Appeal Decision

Appeal Ref: APP/R5510/D/22/3298909

53 Linden Avenue, Ruislip HA4 8TZ

- The appeal is made under section 78 of the Town and Country Planning Act 1990 against a refusal to grant planning permission.
- The appeal is made by Mrs K Green against the decision of the Council of the London Borough of Hillingdon.
- The application Ref 42546/APP/2021/3950, dated 22 October 2021, was refused by notice dated 31 March 2022.
- The development proposed is first floor side/part rear extension and front porch.

Sheet  
03

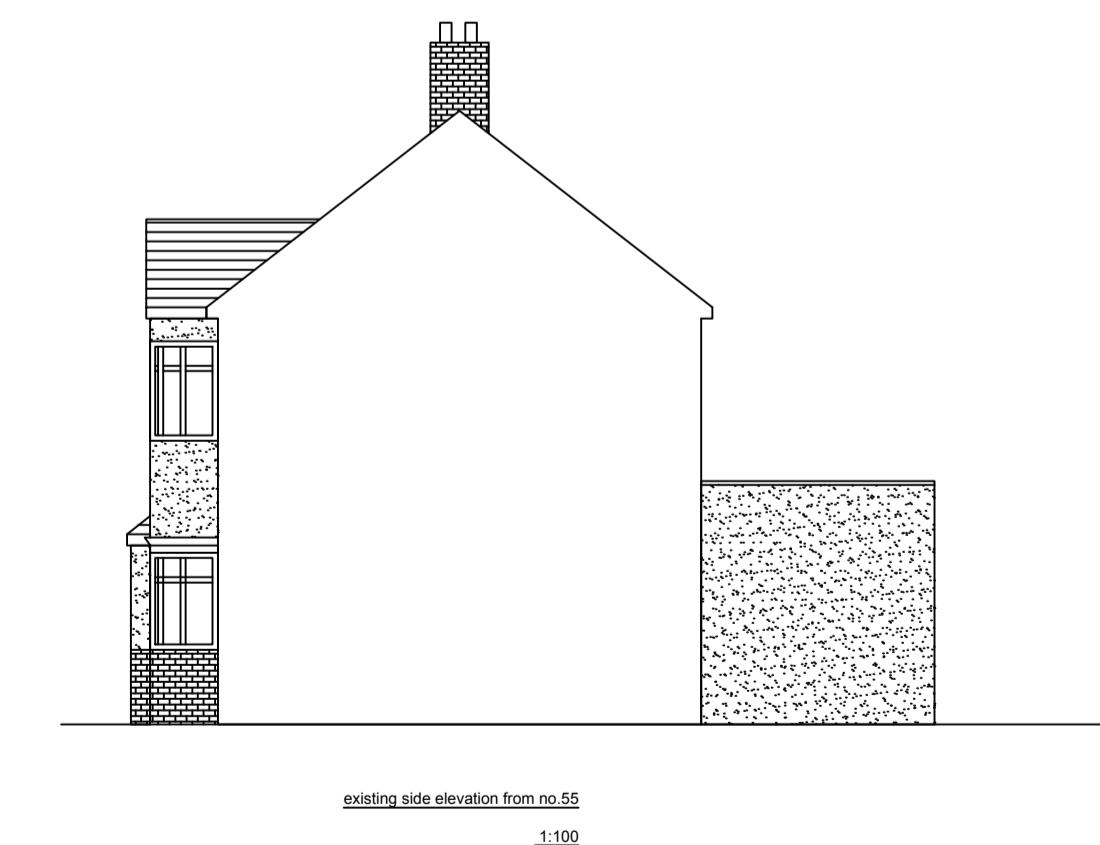
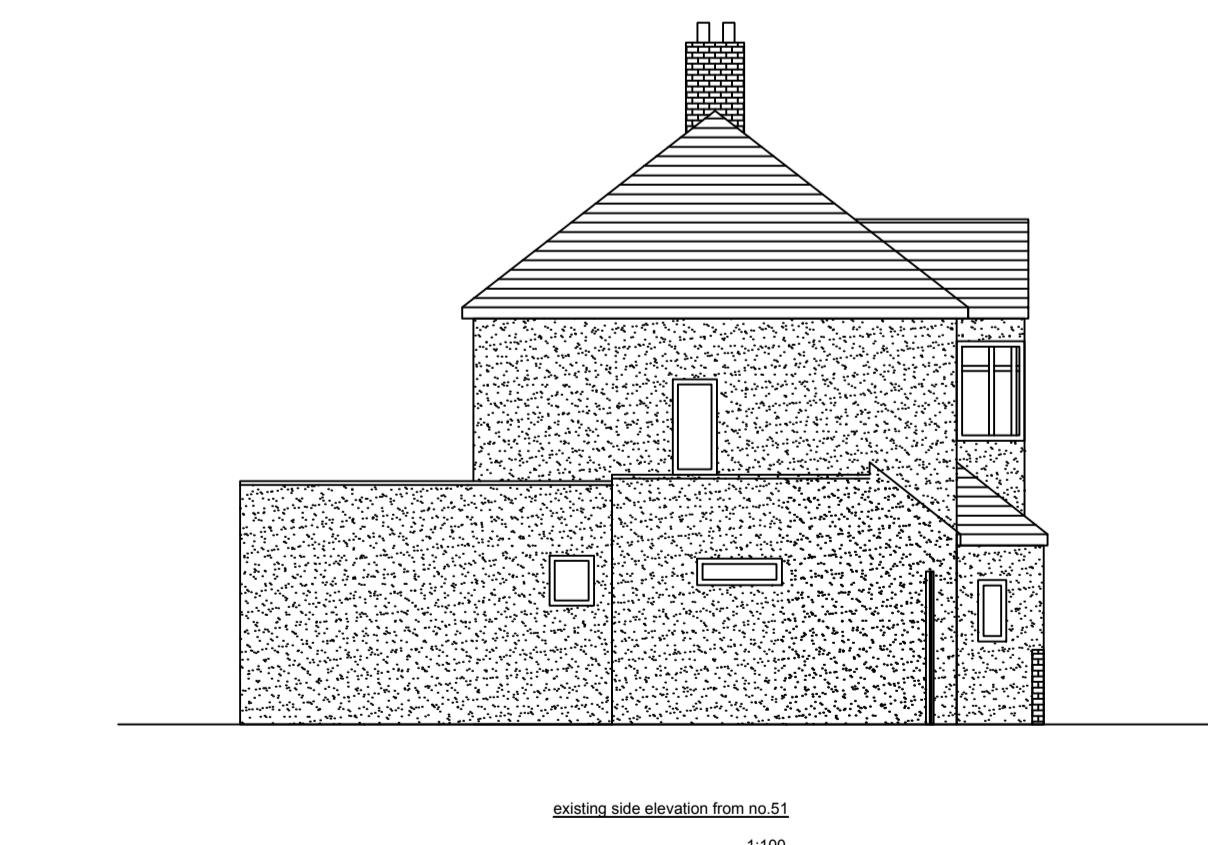
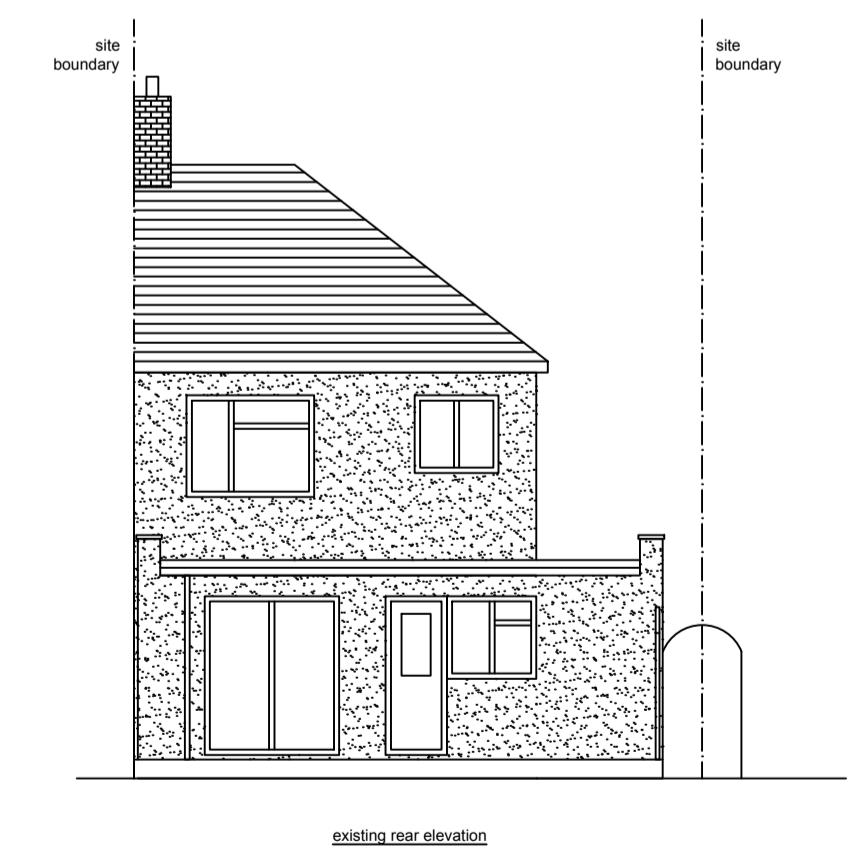
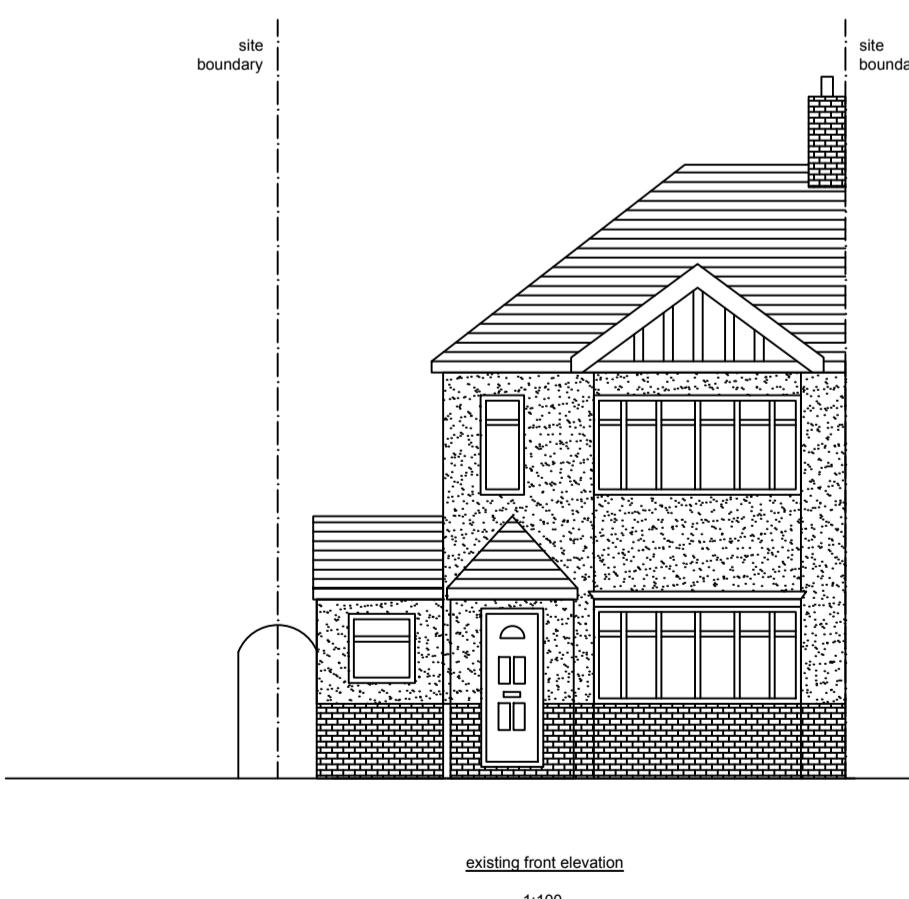
4. The proposed front porch extension would not be of significant depth, and would be set appreciably below the height of the first-floor level windows to the appeal dwelling. There would also be separation to the side of the two-storey bay which I consider would remain the most prominent feature to the front of the appeal building, and I find that the front extension would appear proportionate and sympathetic to the host property overall. Moreover, it would not be out of keeping with the assorted and in many cases fairly large front porches and extensions that I observed to other dwellings on Linden Avenue, and so would not appear incongruous or unduly prominent.

5. The side extension would not be set back from the adjacent front elevation of the appeal building, and would wrap around to its rear. However, it would be of modest width relative to the dwelling, and it would also be of significantly lower height. I find as a result that this element of the development would also appear generally subordinate, and I am satisfied that the overall bulk of the side and rear extension would not unacceptably dominate the host dwelling.

6. Be that as it may, the proposal would conflict with the requirement within Policy DMHD 1 of the Hillingdon Local Plan: Part 2 – Development Management Policies 2020 ('LPP2') for two-storey side extensions to be set in a minimum of 1m from the side boundary. Given that it would also be aligned with the front of the dwelling in further conflict with the requirement in DMHD 1 for a set back, the extension would be prominent from the street where it would infill much of the existing space to the side of the dwelling at first-floor level and significantly restrict views through to the rear of the site. The neighbour at 51 Linden Avenue already has a two-storey side extension. This is of slightly reduced width at first-floor level, but even so and despite the presence of the alleyway that would be maintained between these dwellings, I find that the close proximity of the development to this neighbour would result in an uncomfortably tight relationship that would stand out against the more generous spacing that is typically maintained between the upper storeys of buildings along the street. For these reasons, I consider that the proposal would detract from the character and appearance of the street scene.

10. For these reasons, the existence of other side extensions in the locality does not justify the harm I have identified and the conflict with provisions of the development plan. I have determined the appeal before me on its own merits, and I find that the two-storey side extension proposed would be a discordant and intrusive feature that would harmfully erode the characteristic pattern of separation between the upper storeys of dwellings on Linden Avenue.

13. The front porch would reduce the depth of the site frontage. The appellant comments that the retained frontage would have a depth of 4.9m which would be sufficient to accommodate a vehicle, but this is not clearly demonstrated on the submitted plans and would seem likely to result in vehicles parked very close to the entrance door which could obstruct access to the dwelling, or in vehicles overhanging the footway.
